Subject: Eagle Rising SF2225 Plat Filing 1 Response Letter and EDARP Upload

Our responses to the EPC October 2, 2024, and October 3, 2024 Plat and related documents review comments have been uploaded EDARP.

| EDARP Review Comments | | | | | | | | | | | | | | |
|-----------------------------------------------------|-------------------------------------|--------------------------------------|-------------|--------------------|-----------------|------------------|------|------------------------------------------------------------------------------------------------------------------------------------------------------------------------------------------------------------------------------------------------------------------------------------------------------------------------------------------------------------------------------------------------------------------------------------------------------------------------------------------------------------------------------------------------------------------------------------------------------------------------------------------------------------------------------------------------------------------------------------------------------

SHEET 4 OF 6

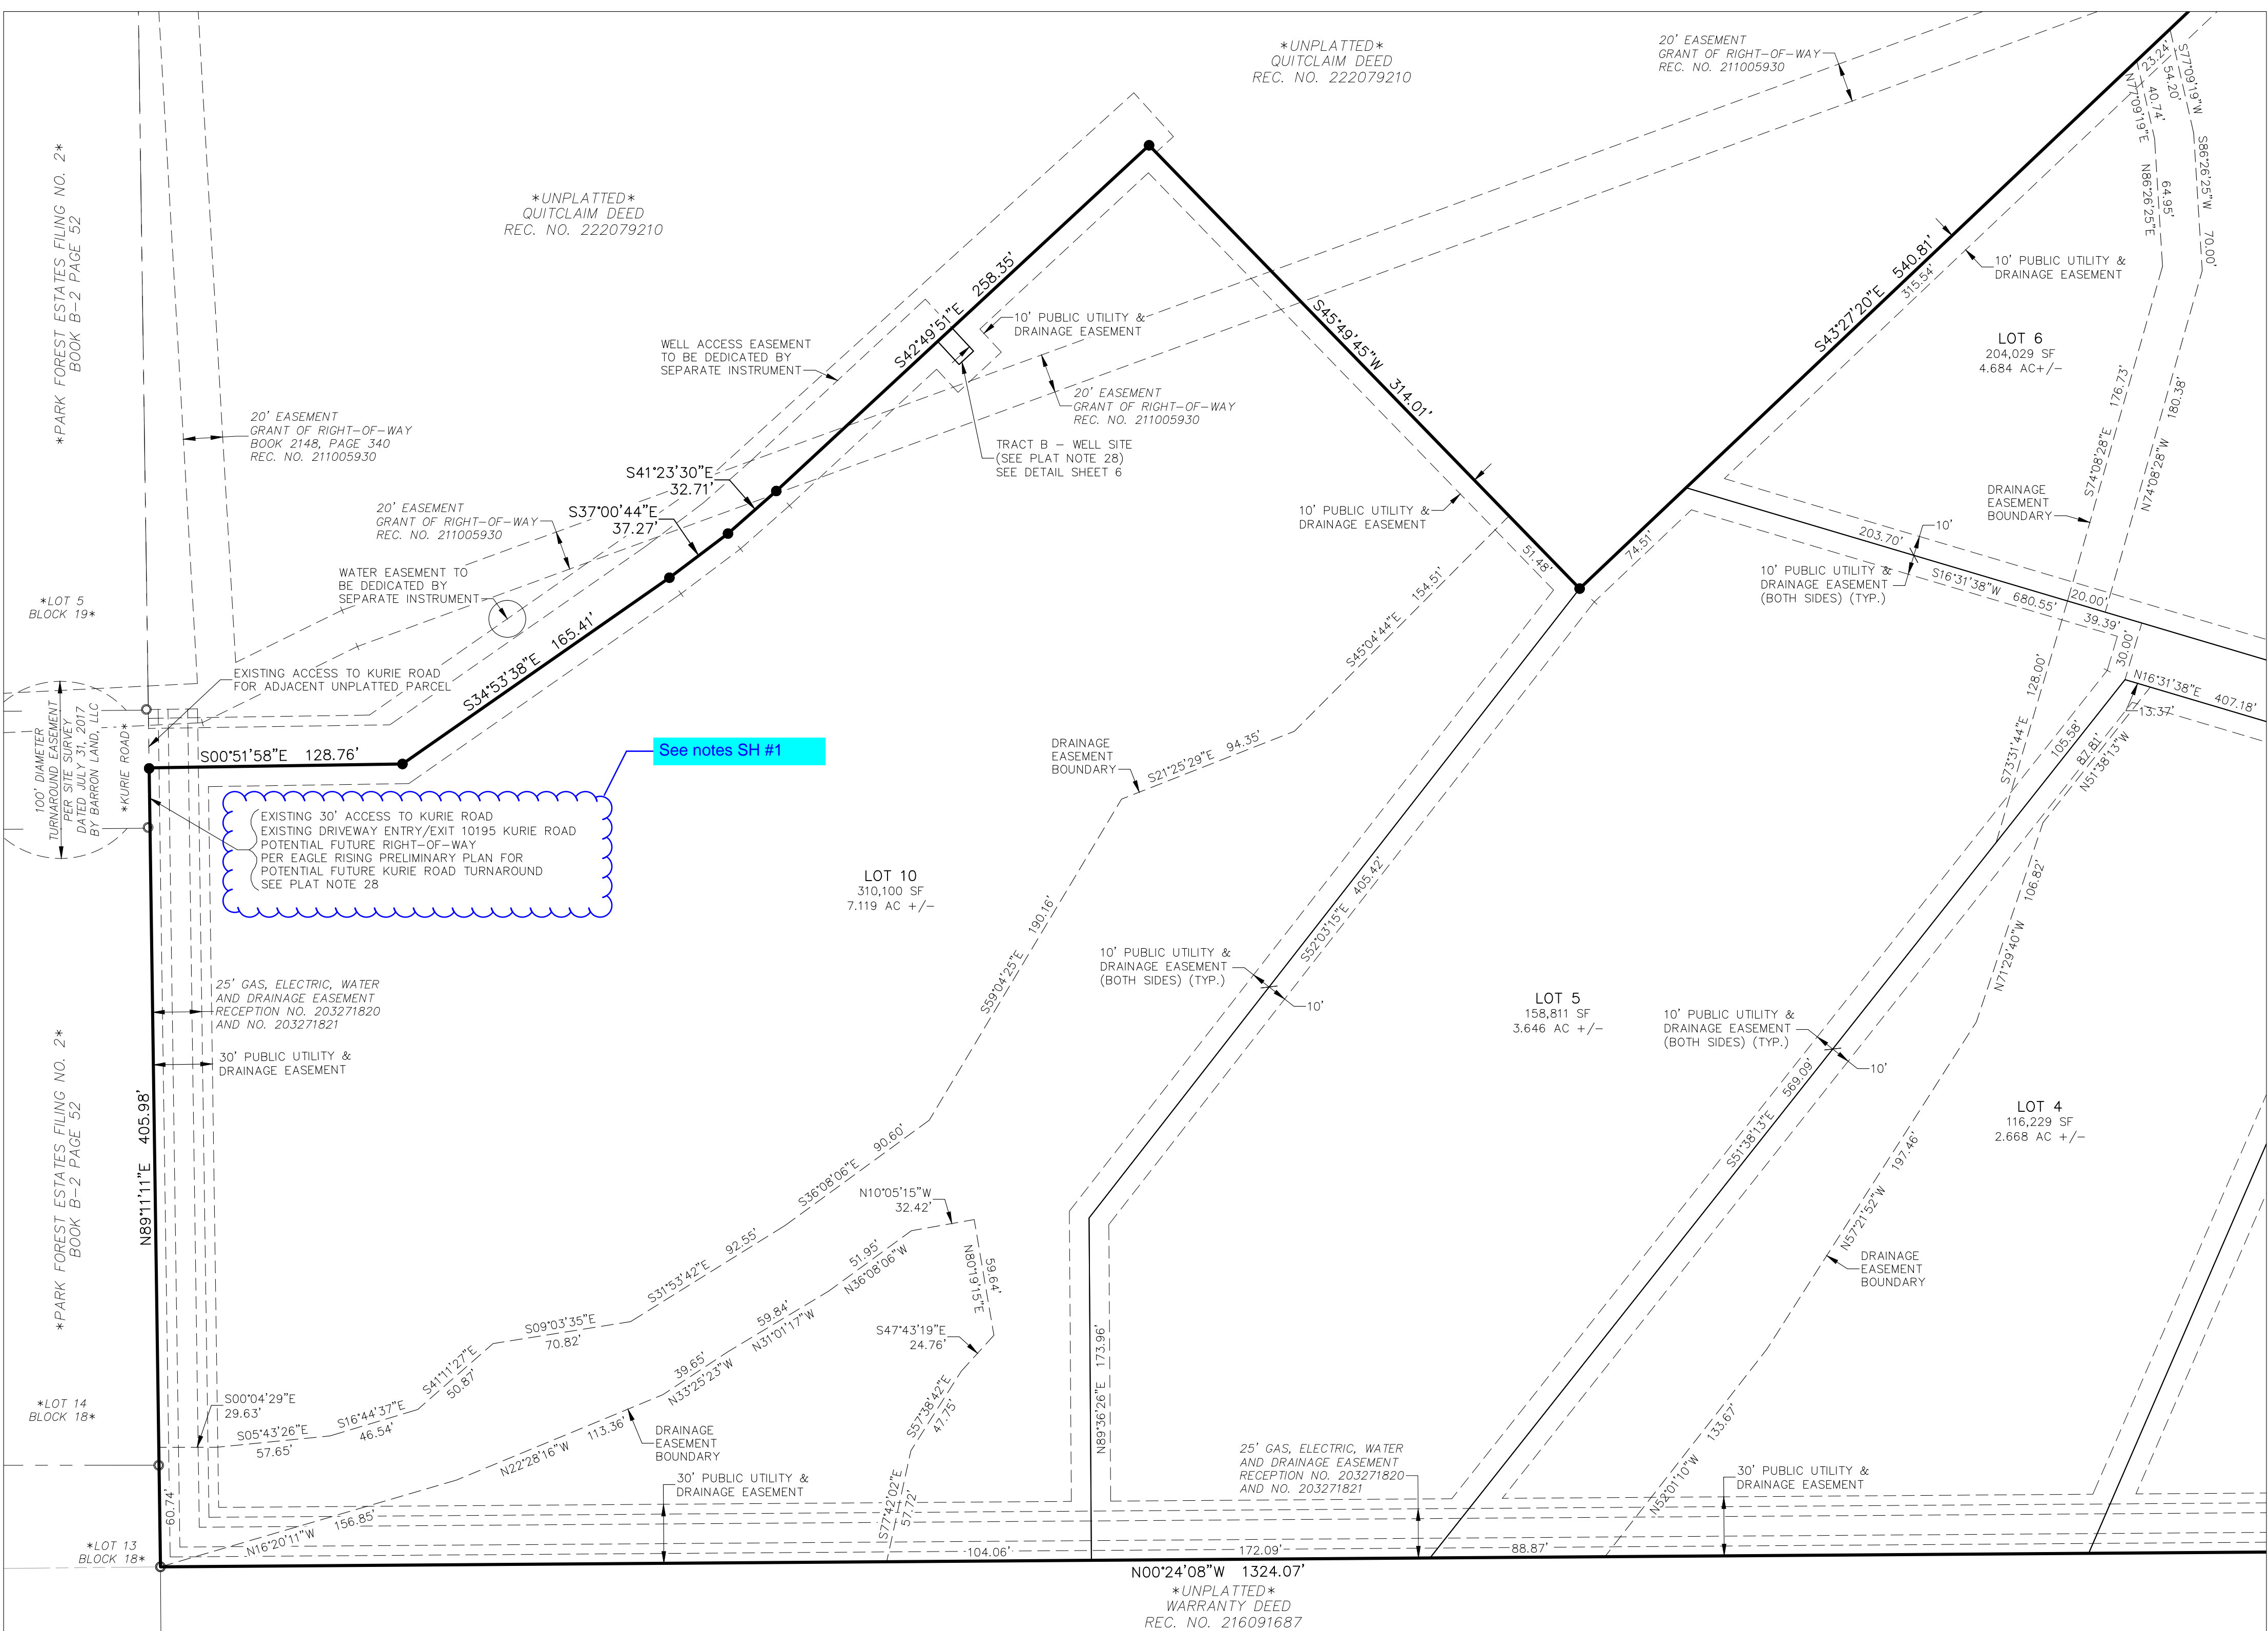
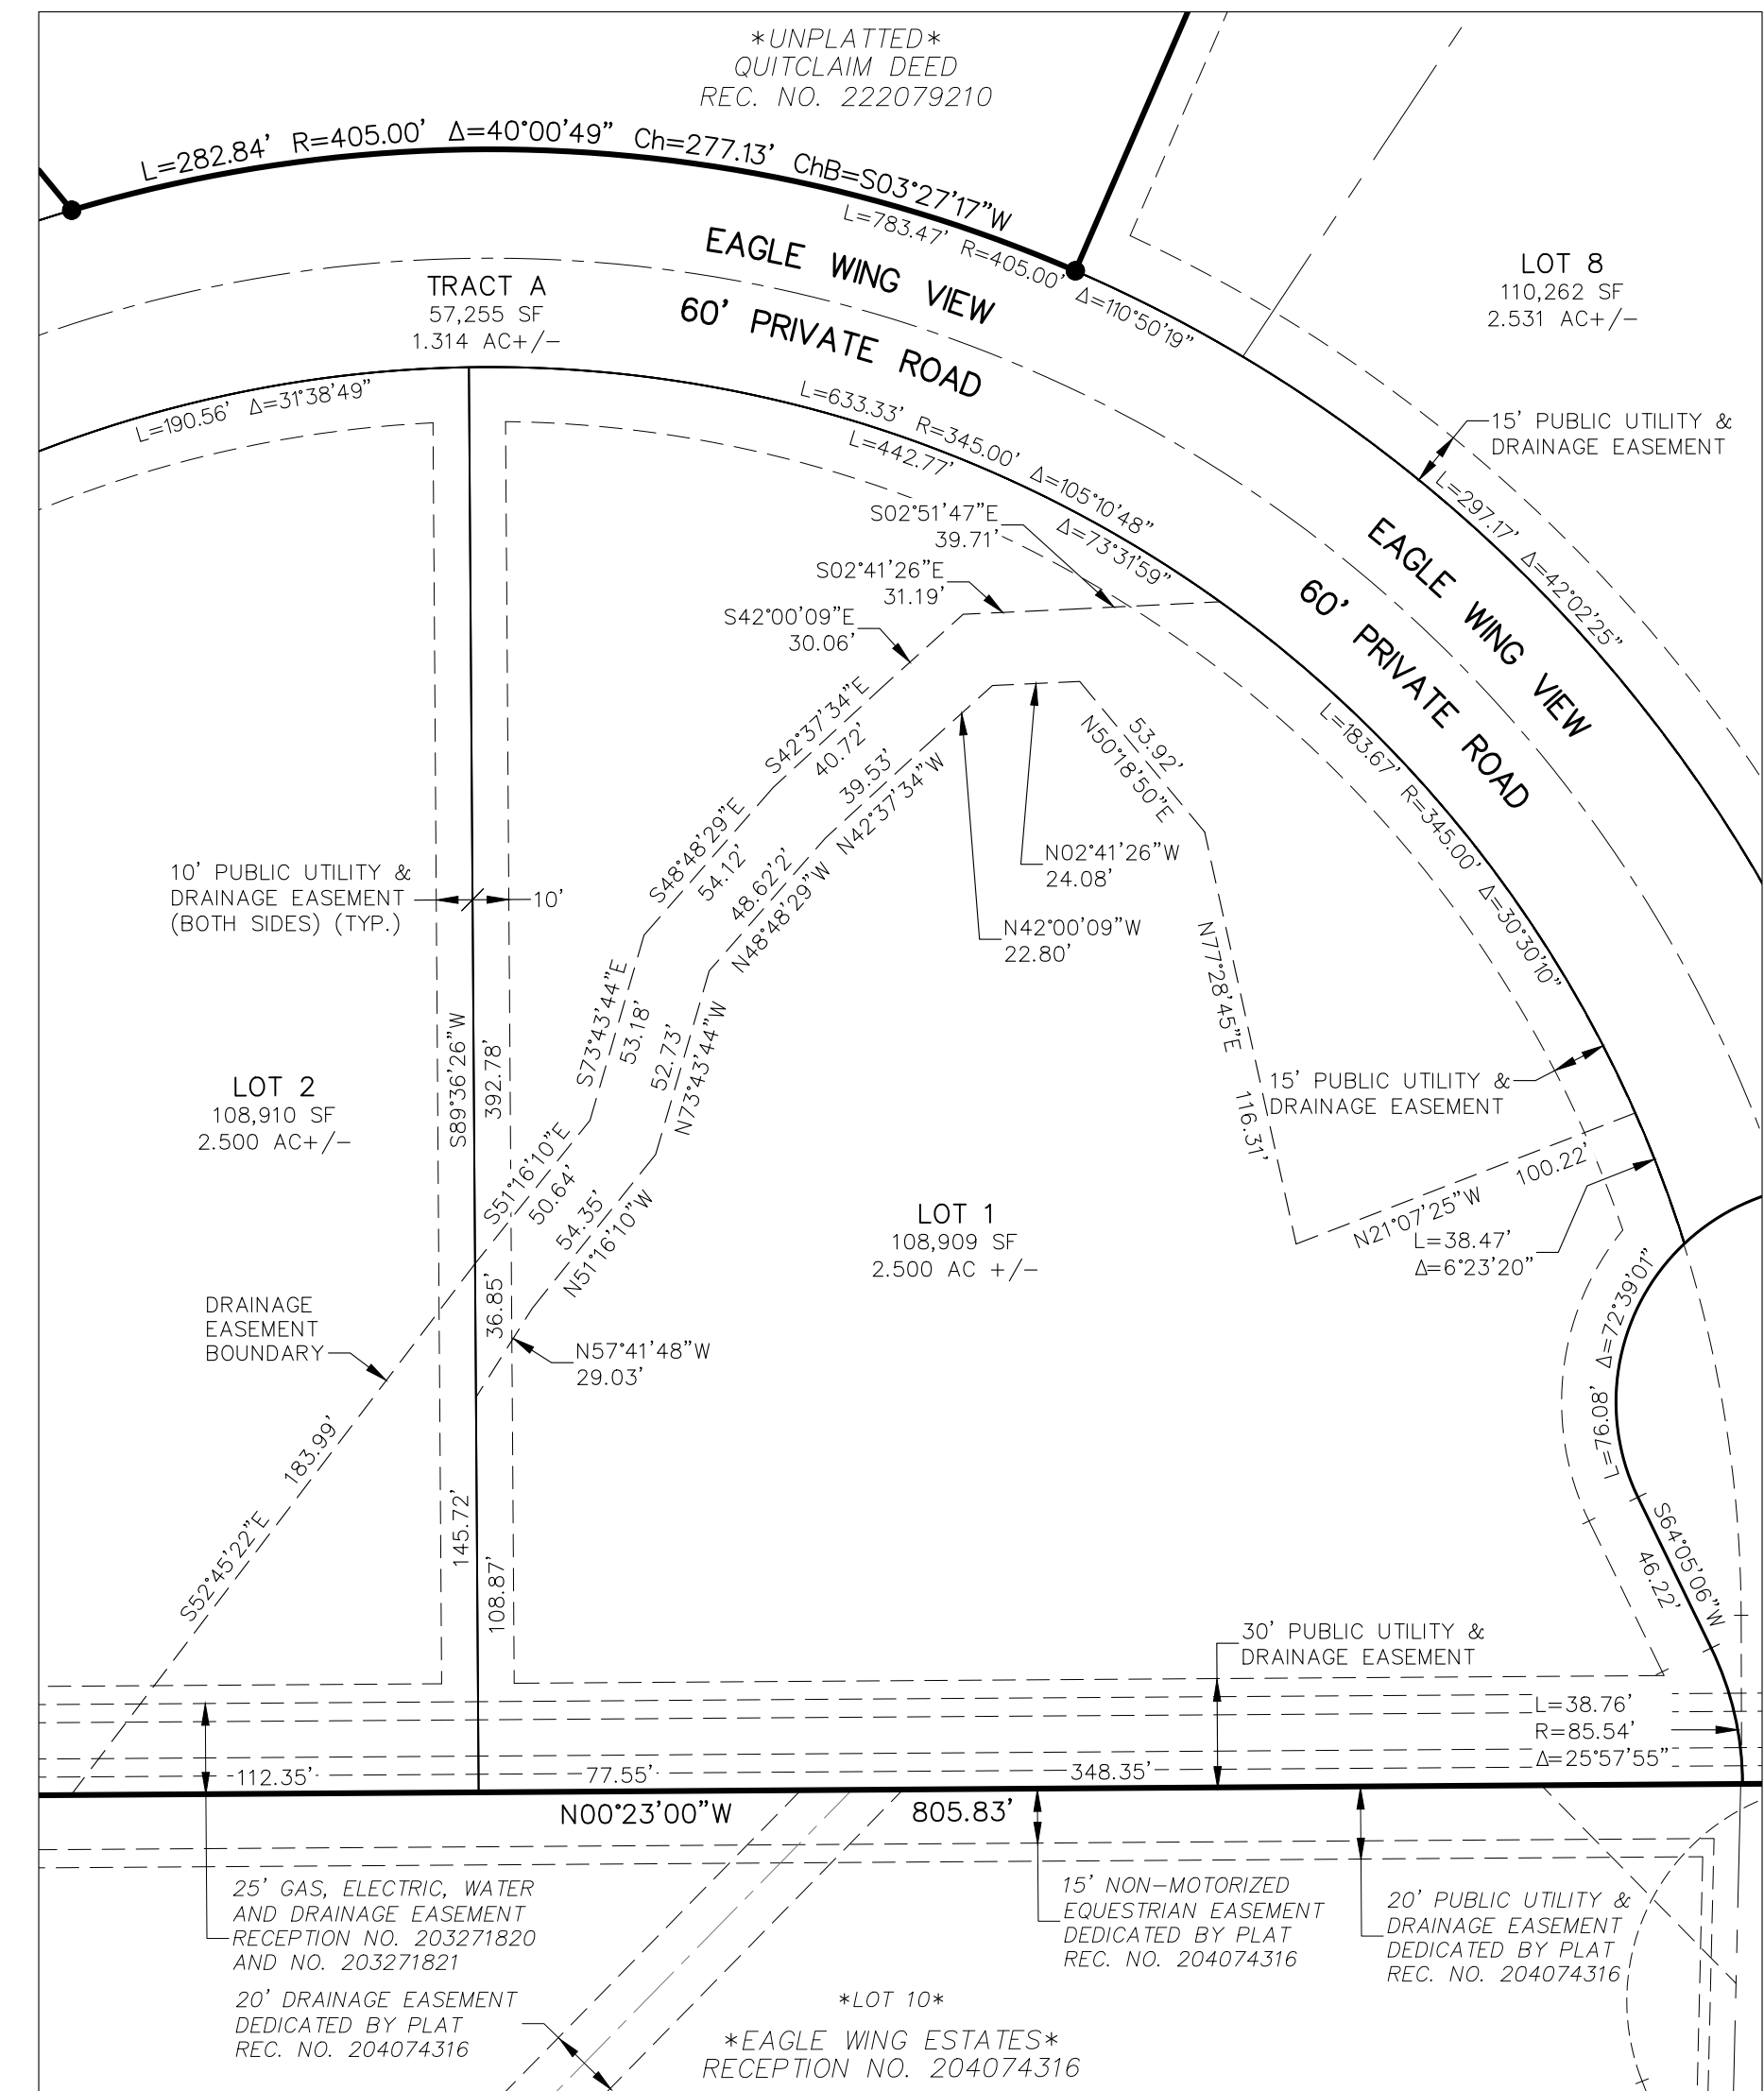
| EDARP Review Comments | | | | | | | | | | | | | | |
|-----------------------------------------------------|-------------------------------------|--------------------------------------|-------------|--------------------|-----------------|------------------|------|----------------------------------------------------------------------------------------------------------------------------------------------------------------------------------------------------------------------------------------------------------------------------------------------------------------------------------------------------------------------------------------------------------------------------------------------------------------------------------------------------------------------------------------------------------------------------------------------------------------------------------------------------------------------------------------------------------------------------------------------------------------------------------------------------------------------------------------------------|------------------------|-------------------------|-------------------------------------|------|--------------------------------------------------------------------------------------------------------------------------------------------------------------------------------------------------------------------------------------------------------------------------------------------------------------------------------------------------------------------------------------------------------------------------------------------------------------------------------------------------------------------|--------------------------------------------------------|
| 14 | Final Plat Eagle Rising Filing No 1 | PCD Engineering Division | Yes | Edward Schoenheit | 10/3/2024 10:53 | (Plat redlines) | 4 | please label as drainage easement | A - Approve | 10/21/2024 | Final Plat Eagle Rising Filing No 1 | 4 | See update | |
